From: Justin Kilgore
Sent: Monday, December 19, 2022 10:26 AM
To: Kari Parsons
Cc: Marcella Maes; Petra Rangel
Subject: FW: Haven Valley - File Number: PUDSP217
Attachments: Haven Valley Spencer Email.pdf; 1 - Original Response 11292022.pdf; 2 - Summary 12172022.pdf

From: SUSAN SPENCER <scspencer99@msn.com>
Sent: Saturday, December 17, 2022 11:35:37 AM
To: Longinos Gonzalez, Jr <LonginosGonzalezJr@elpasoco.com>
Subject: Haven Valley - File Number: PUDSP217

DATE: November 29, 2022
TO: El Paso County Planning Commission/Board of County Commissioners
FROM: Susan Spencer
SUBJECT: Planned Unit Development/Preliminary Plan – Haven Valley
Response: Opposition/Concern

5 6' OPAQUE CEDAR FENCE
N.T.S.

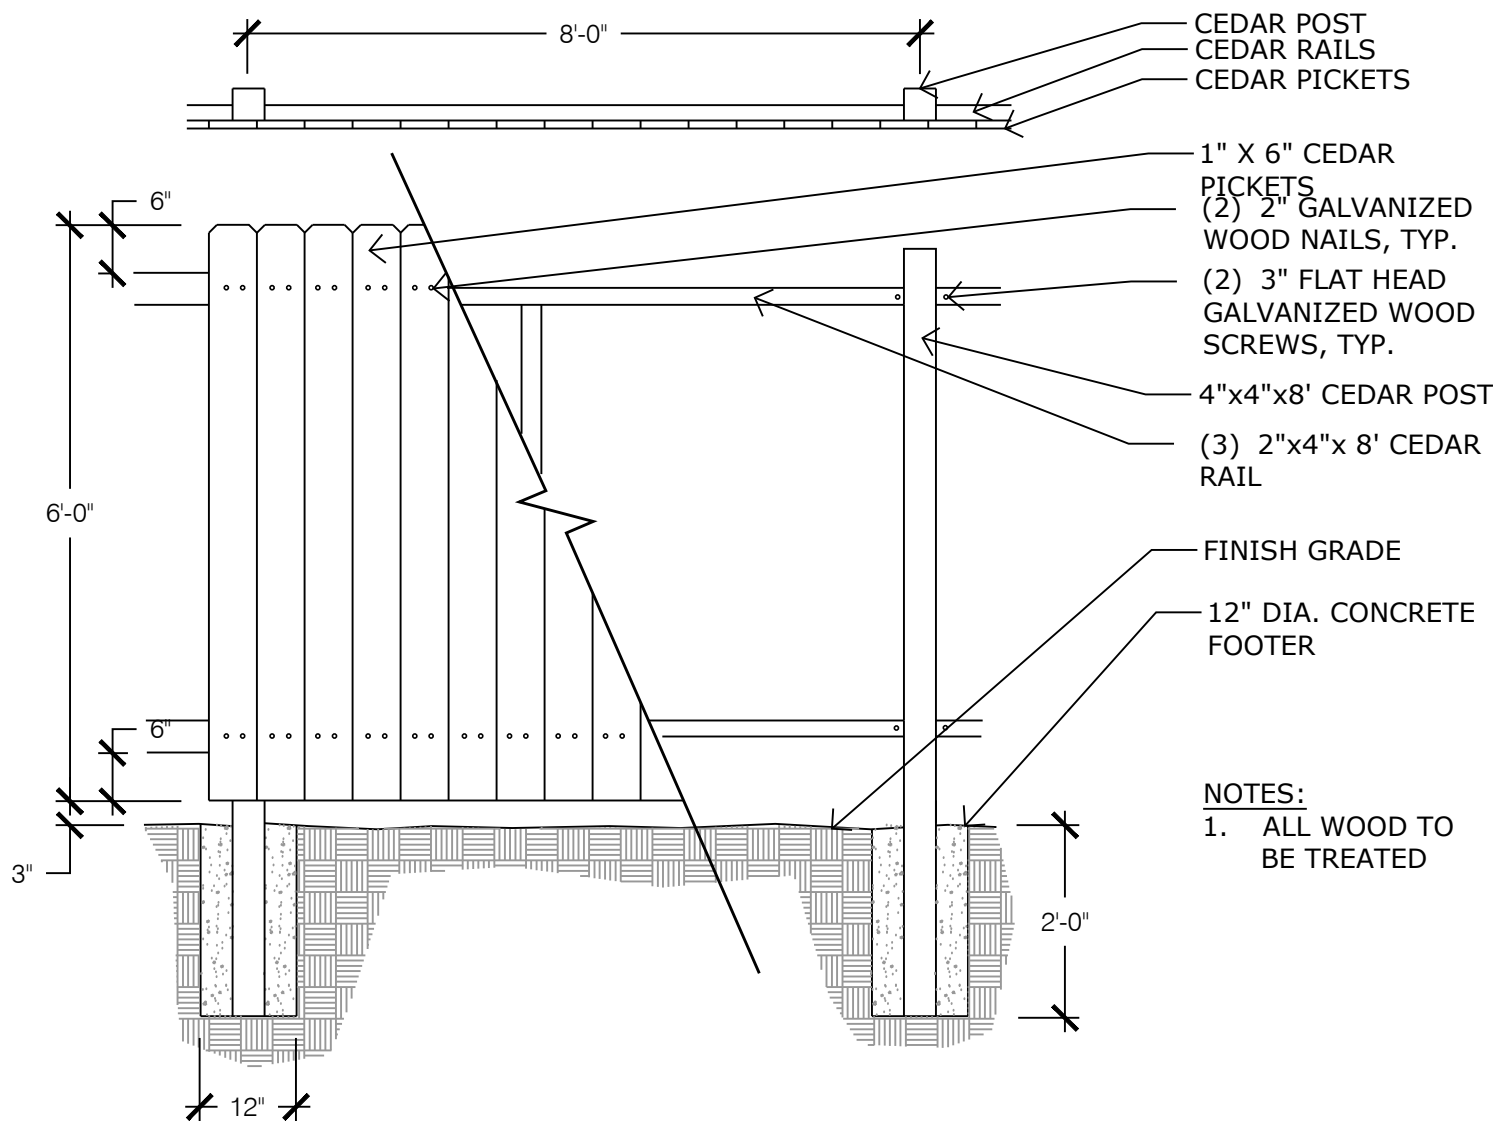
The 6 foot opaque fencing with a landscape buffer proposed for the east and south boundary also be installed on the north and west to include the buffering landscape.

If approval is given by EPC Commissioners, I would also ask that the 6 foot opaque fencing with a landscape buffer proposed for the east and south boundary also be installed on the west boundary to include the buffering landscape.
